CITY OF ALBUQUERQUE

February 07, 2012

**Re: Inez Elementary School Cafeteria, Fine Arts/Classroom and Renovations
Grading and Drainage Plan
Engineer's Stamp Date 1/24/2012 (J19D067)**

SHEET NO.: C-101

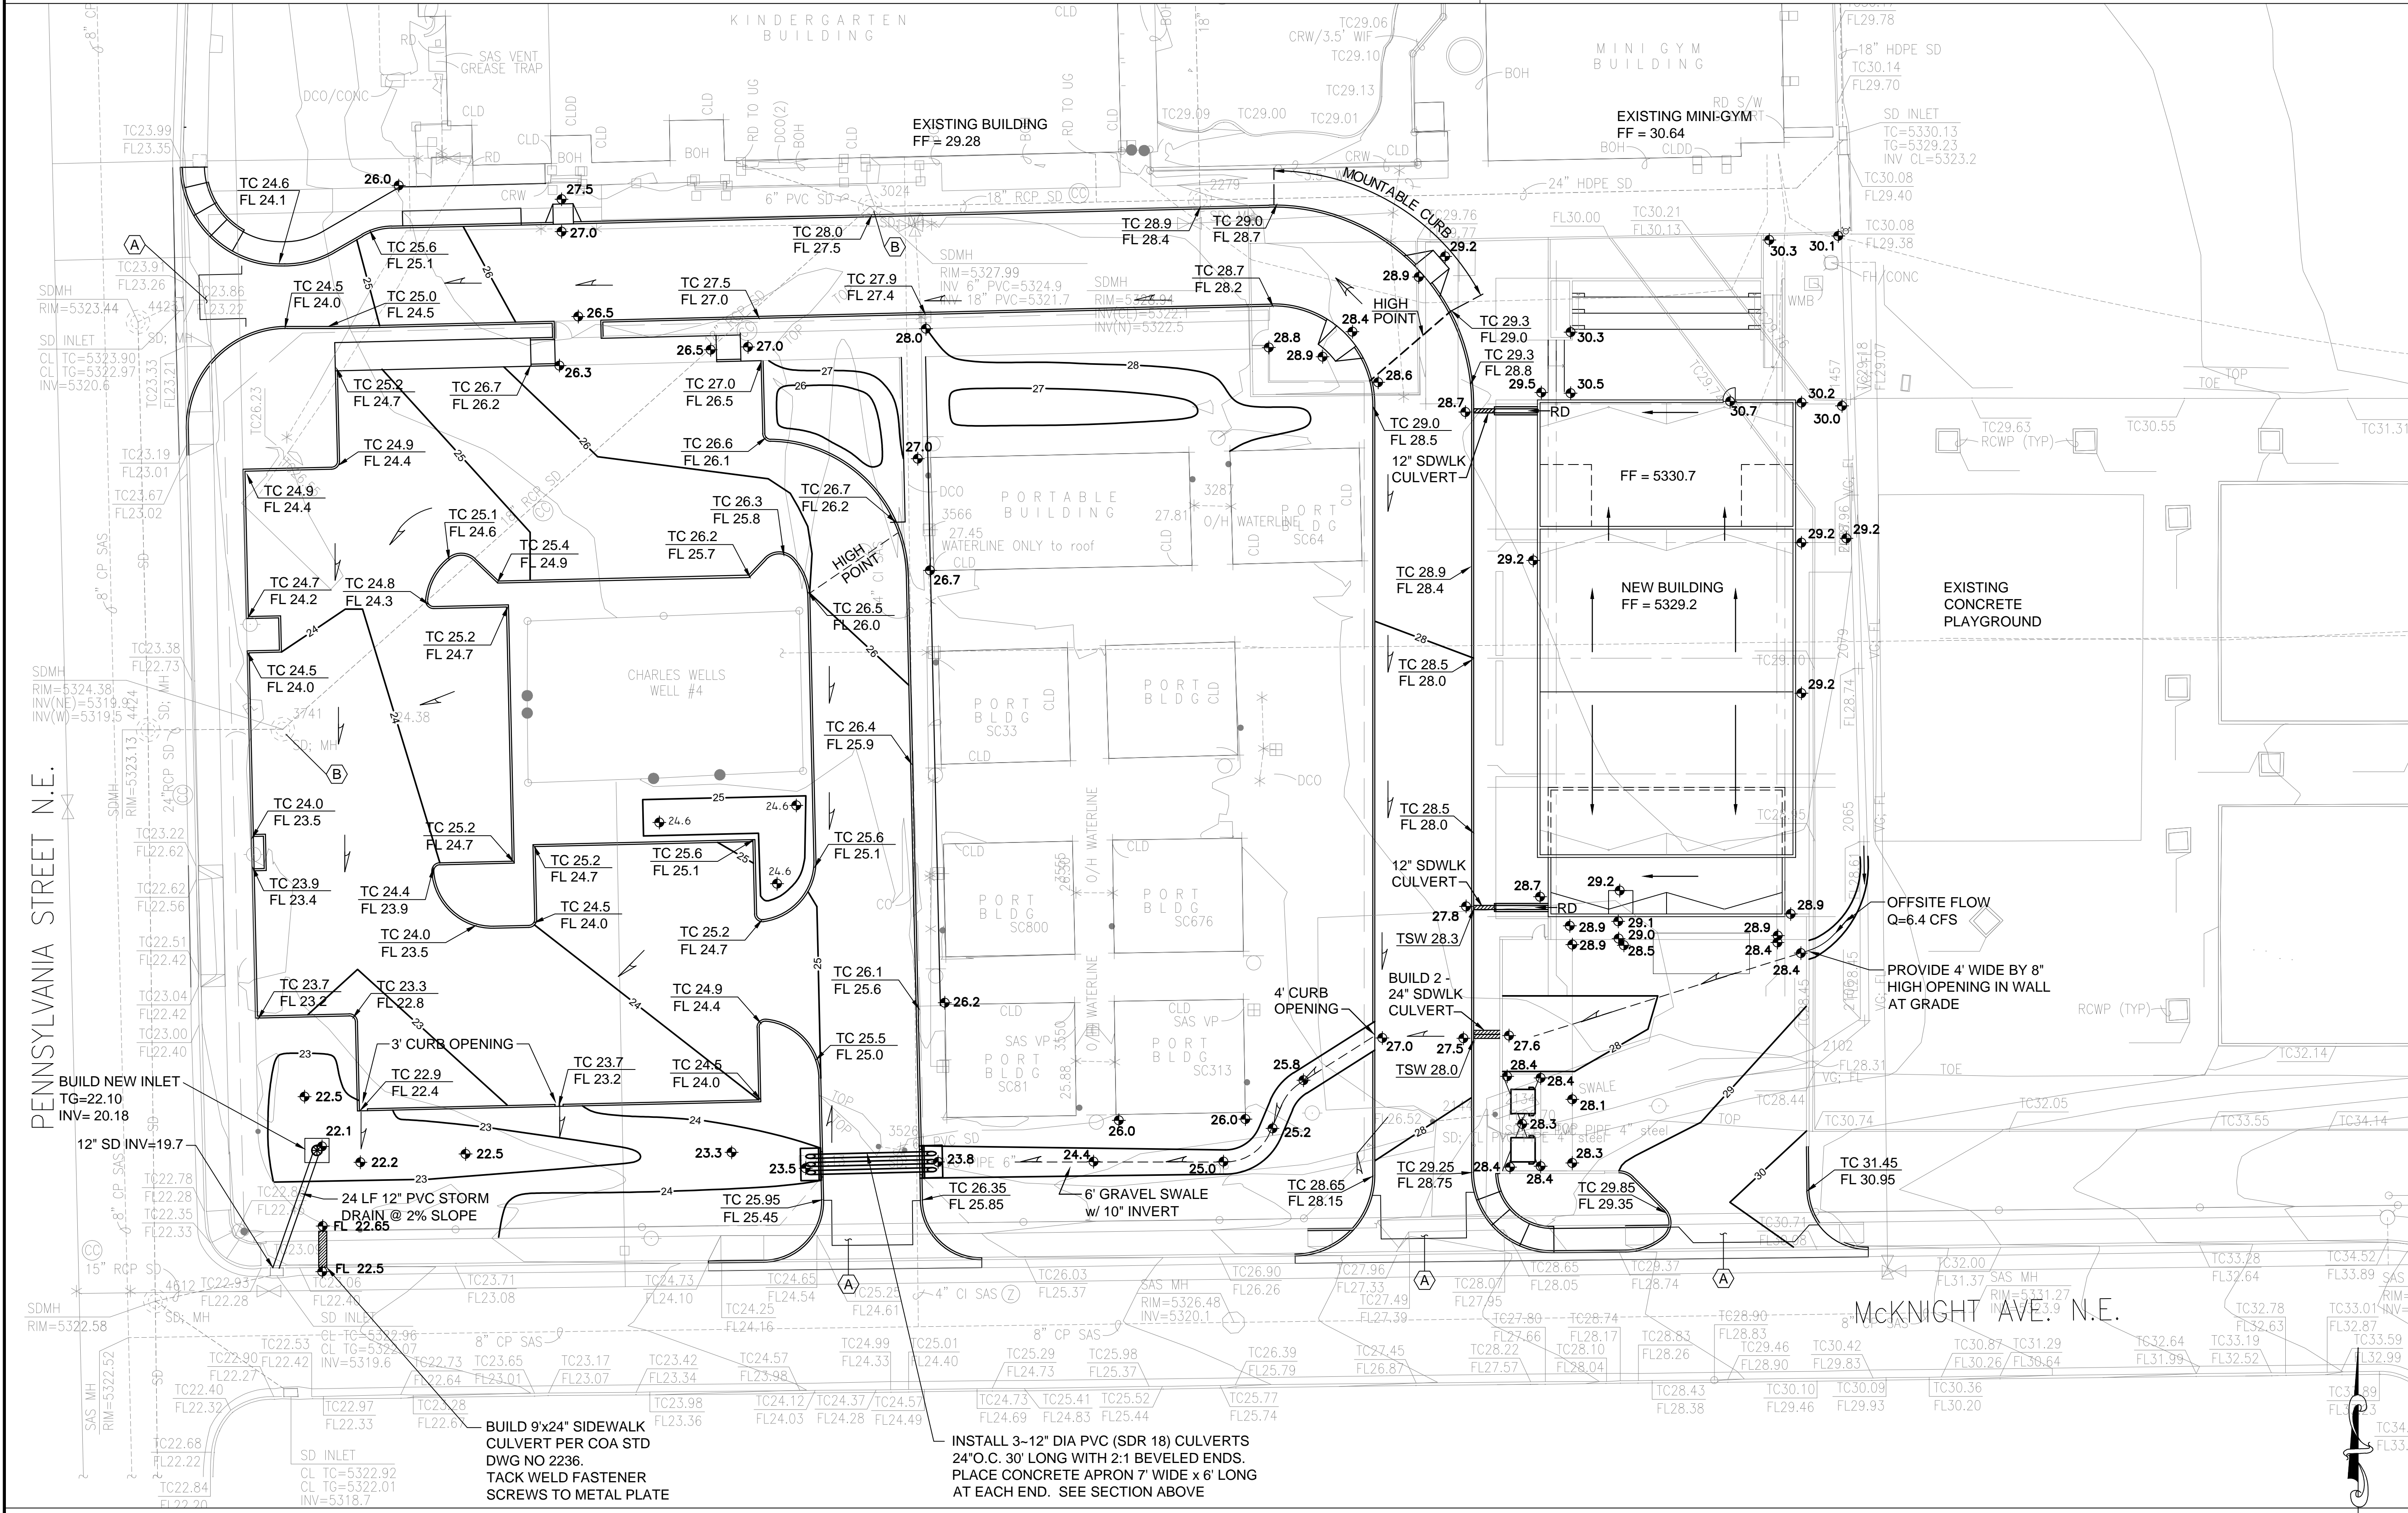
- Please double check the location of the high point within the loop road, connecting McKnight Ave. NE and Pennsylvania St. NE, against the Master Drainage Plan. It appears that the sidewalk culvert north of the building with finish floor elevation of 30.70 will drain north instead of south.

- Call out the curb opening size by elevation 27.00 across the 24" sidewalk culvert within the loop road north of McKnight Ave. NE.
- Include additional spot elevation against the portable building SC313 to assure that no runoff will drain under the building at the location where the proposed swale turns south.

- Provide calculation for the proposed swale.
- Add a section at the 3-12" culvert crossing. Is there adequate coverage over the pipes? Include pipe flow calculations.

- SO-19 Notes are not shown on the plan.
- Provide calculations for the sidewalk culverts and proposed openings.
- Does the 18" Domed Grate have adequate capacity? Provide calculations (assume a 50% clogging factor). May want to consider raising top of pond elevation to 23.70. Provide a detail for connecting the 18" PVC to 18" RCP.
